Markup Summary

[5] 204 GRADING AND EROSION CONTROL PLAN (2)

DESIGNED EJG	DRAWN KRK	CHECKED EJG
SCALE (H): 1" = 80' SCALE (V):		
DATE: DECEMBER 20, 2018		
PROJECT NO. 096495003		
DWG. NAME 096495003_EC		
SHEET NO. 219

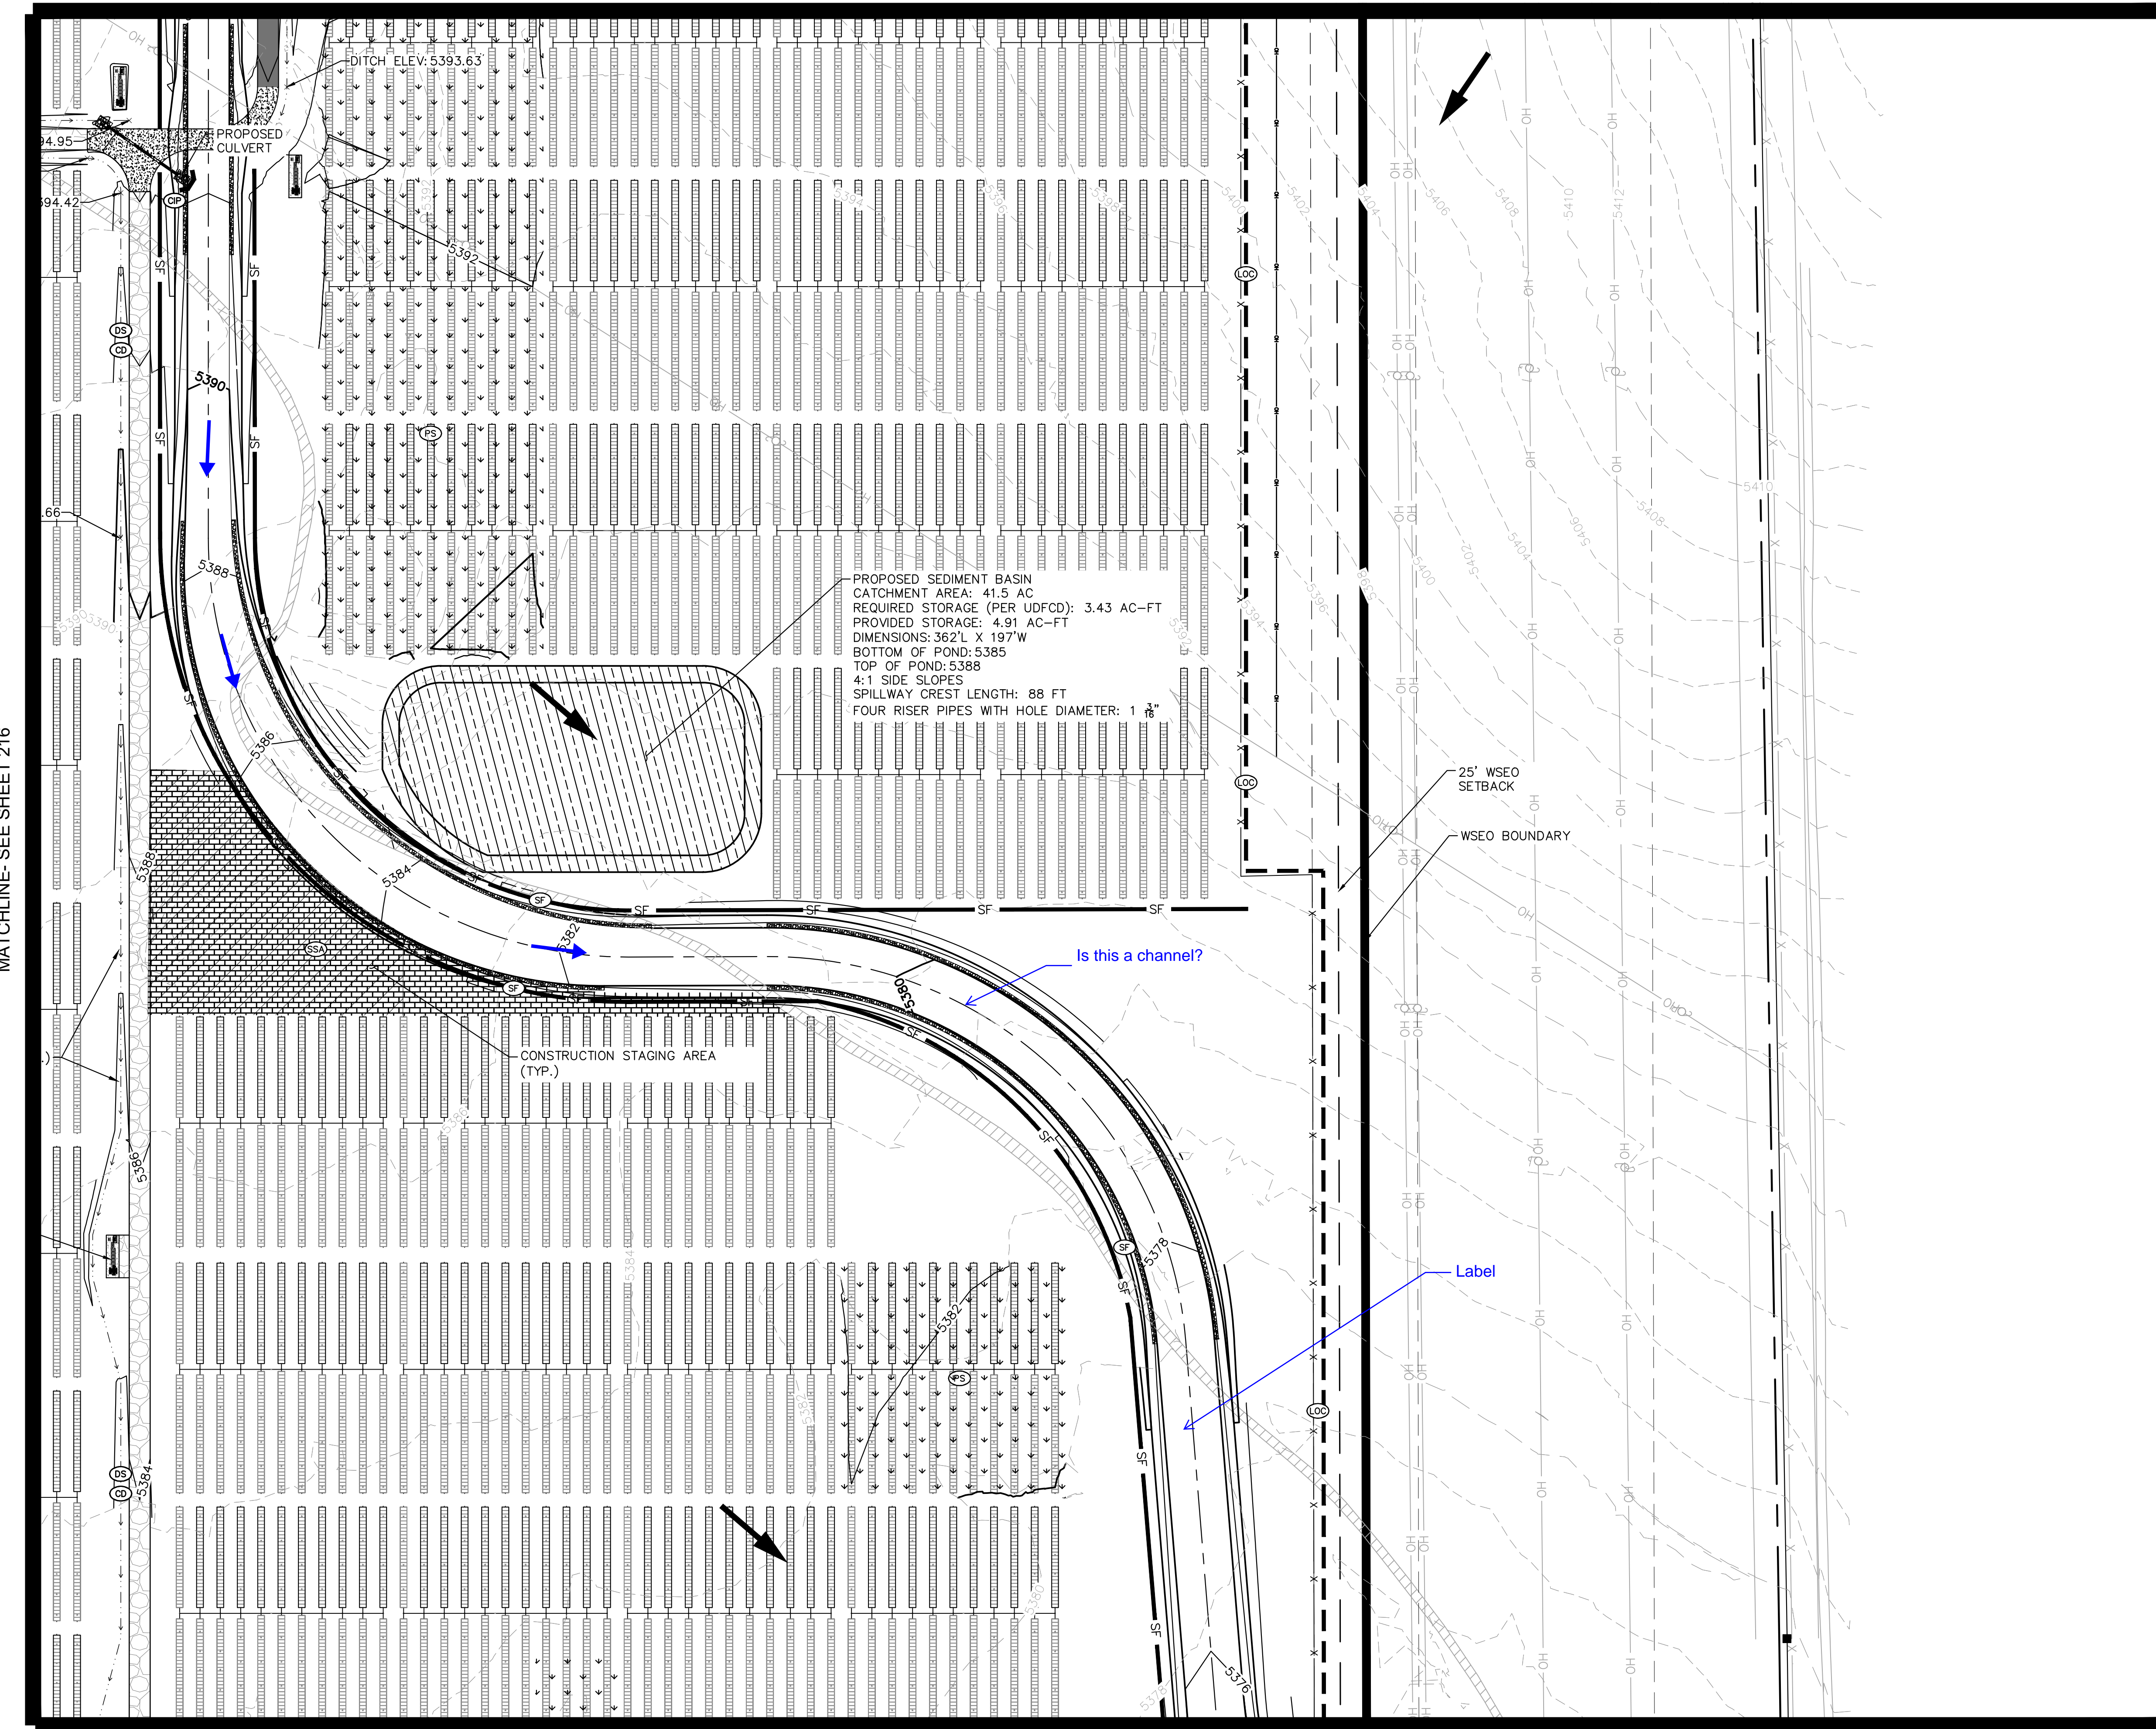
Subject: Callout
Page Label: [20] 219 GRADING AND EROSION CONTROL PLAN Verify silt fence placement - it should parallel contours.
Author: dsdrice
Date: 1/31/2019 11:19:19 AM
Color: ■

Subject: Arrow
Page Label: [20] 219 GRADING AND EROSION CONTROL PLAN provide flow arrow
Author: dsdrice
Date: 1/31/2019 11:19:42 AM
Color: ■
